Recommendation Report for Planning Permission for Works or Extension to a Dwelling

REF NO: P/104/19/HH

LOCATION: 97 Harbour View Road
Pagham
PO21 4RJ

PROPOSAL: Single storey side/rear extension and part conversion of garage to habitable use.

DRAWING No  
275/04  
SCALE  
1:100  
DATE  
NOT SET  
REVISION  
B  
DRAWN  
CHECKED  
LA

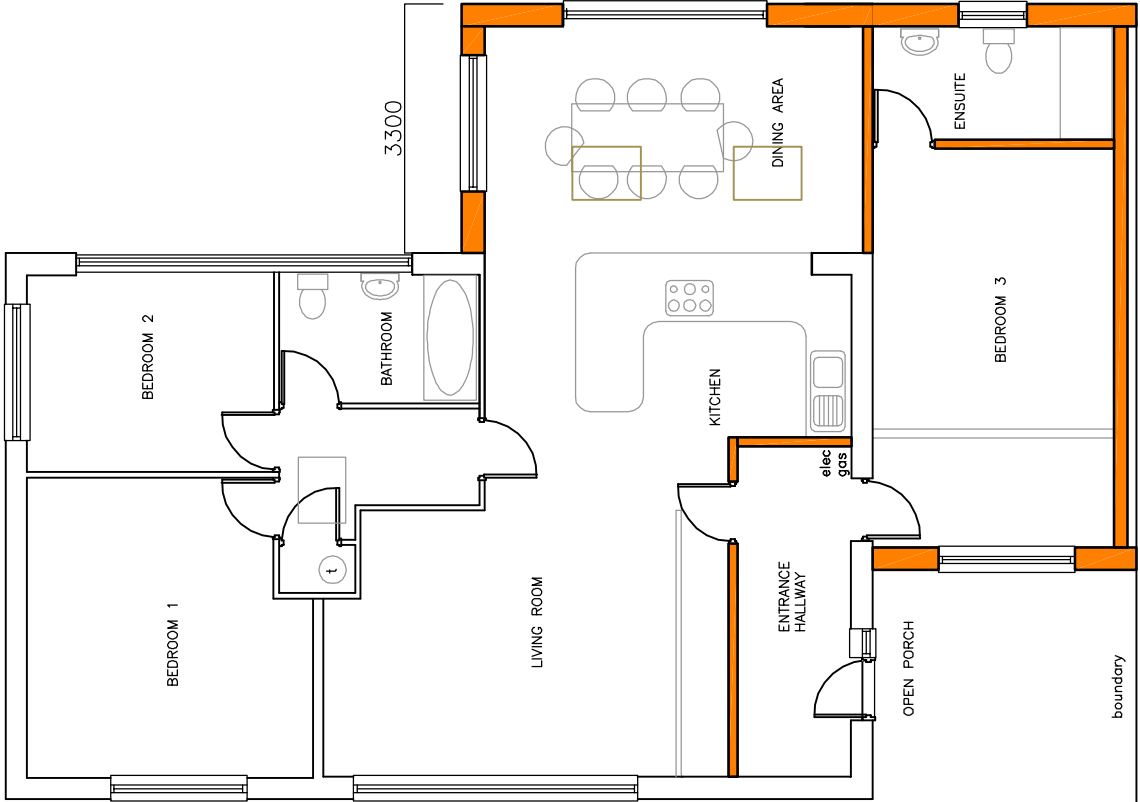
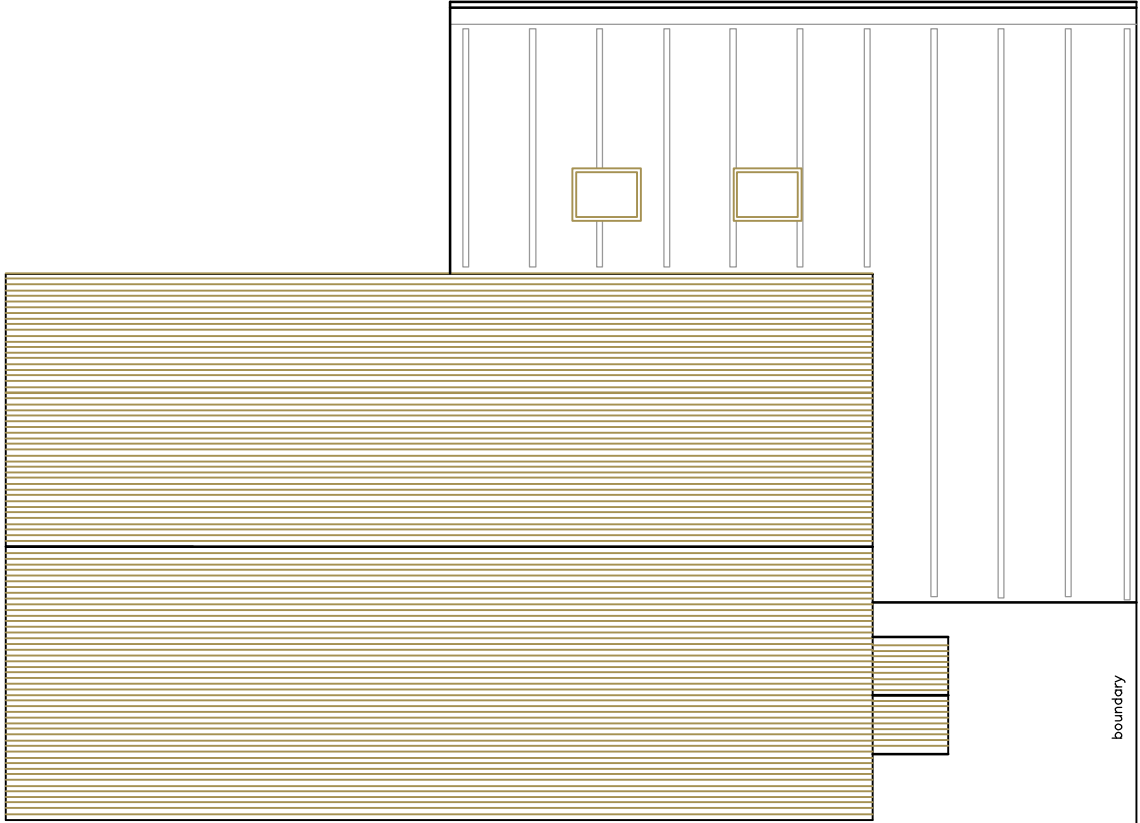
The applicant seeks planning permission for the construction of a rear extension to the established dwelling and connect to the garage which is to be converted and connected through a small side extension. The proposed new development (including the conversion of the garage) will measure approximately 9m wide, 3.3m in depth to the rear and be built to the proposed height of 2.7m.

The proposed rear and side extension will be located 23m from the eastern boundary and 7.5m from the northern boundary, 11m from the western boundary and will run along the southern boundary. On the eastern elevation there is one proposed set of sliding doors and one window looking out to the rear garden. On the eastern elevation there will be 1 No. window and one proposed set of bi-folding doors. The northern elevation will host 1 No. window whilst the south elevation will remain solid brick to avoid overlooking. the views gained from the windows and doors are not considered to cause overlooking as they are all single storey and look out over the rear garden of the property. the views gained will be no greater than those currently available from the garden.

Given the location and height of the proposed extension it is not deemed to effect any of the local properties with regards to the 45 degree rule. This is because it is a single storey development that does not cross the view from the neighbouring windows.

DRAWING
PROPOSED
ELEVATIONS
DRAWING No
275/05
SCALE
1:100
DATE
NOT SET
REVISION
B
DRAWN
CHECKED
LA

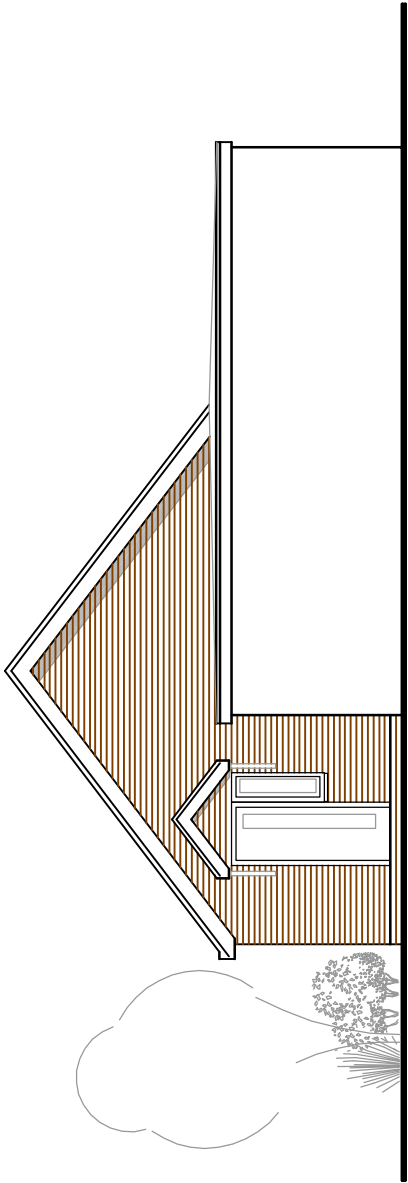
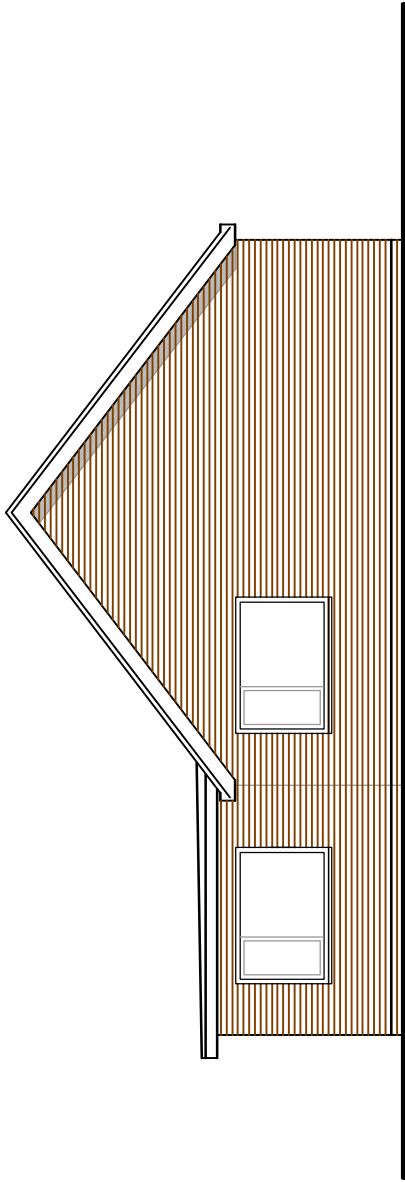
The proposed extension given its location will not be visible from the street scene, however the conversion of the garage will. Due to the nature of the application and the street having other extensions/conversions of a similar nature it is not considered to have a detrimental impact on the character of the host dwelling or the street scene.

With regards to the garage conversion the main change that will be visible will be that the garage door is replaced with a window. As such this is not considered to have a negative impact on the application and does not cause any further overlooking as the views gained are no greater than that which would be available from the door being open. As well as this the views will be of their front garden and driveway.
